THE GEORGE HOTEL

Response to Historic England Comments

March 2023

Sheet Name: Proposed Elevations Sheet 1 of 2

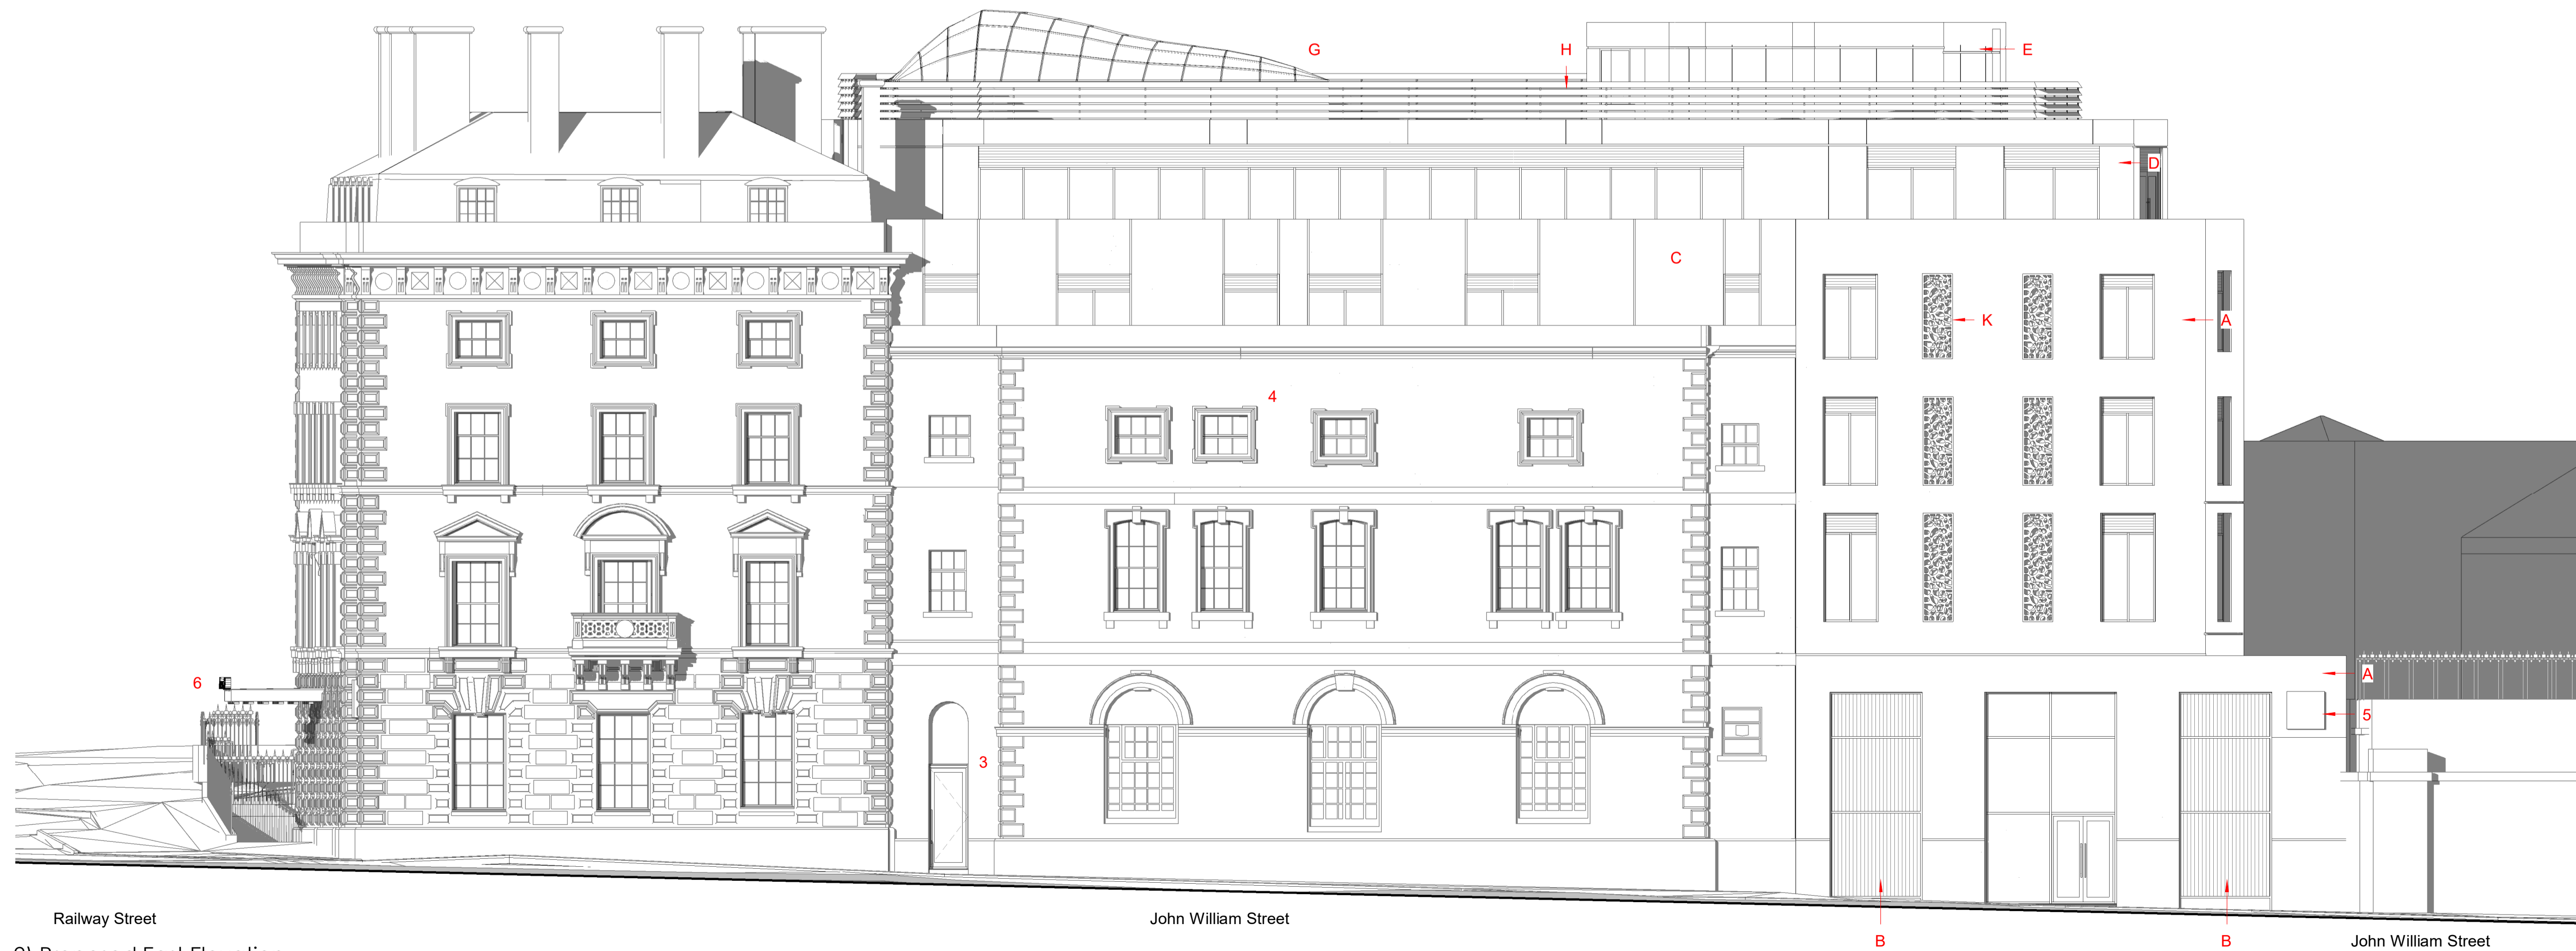
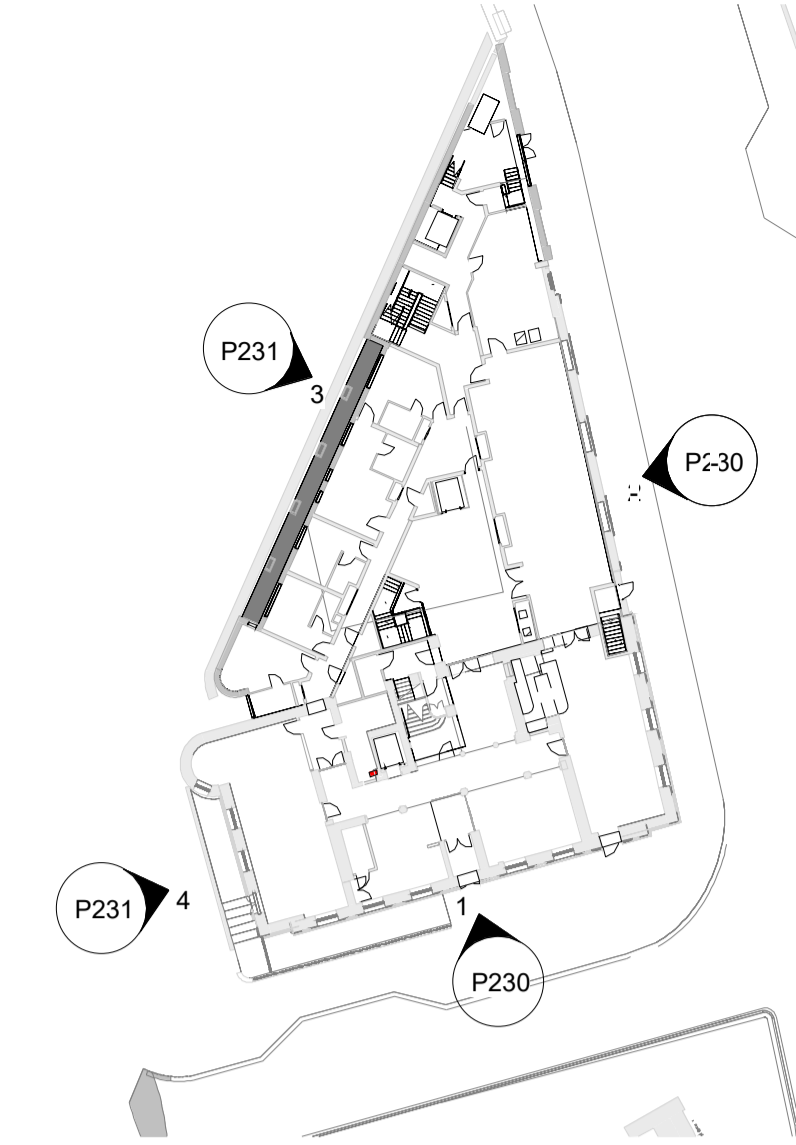
1. Query raised ref. elevational treatment to JWS new build.

- Should read separate to the retained section of façade
- Consider 'book-end' stone element at the apex to split the elevation into 3 distinct buildings.

2. Query raised ref. elevational treatment to car park side

- Stair core wall – should some variety/relief be proposed? Blind windows?
- If apex is amended as 3 above what happens as this element wraps around onto the CP elevation?

- Should top of stone new build section be lifted to align with the top of the stone parapet on block A?

3. Query raised ref. light weight upper storeys

- Can top floor be made less prominent generally?
- Should windows be reduced as per Victorian building?

- 1 Windows on new curved section of east elevation are mirrored as new blind reveals
- 2 Parapet increased on the west elevation and the parapet increase continues on the north to the east elevation

- 3 Level 04 glazing on west elevation lower panel concealed behind the parapet forming a better relationship with the existing mansard roof windows
- 4 Level 03 window types above the Block C façade on the east elevation have been regularised and spaced accordingly

- 5 Level 04 glazing on the east elevation up the end of the Block C façade has been conjoined to appear as a single volume
- 6 New massing to the north simplified by reducing the secondary material and extending the stone façade in the same plane up the new parapet height

- 7 Level 04 glazing on east elevation to the north above the new stone parapet matches item 3
- 8 Level 03 window types within the massing to the north are regularised and arranged uniformly across the east and west elevation

- 9 Level 01 & 02 windows types sitting in stone façade changed to match and arranged to form a sense of symmetry on the John William Street and echoed on each side to form a feature where the building façade converges
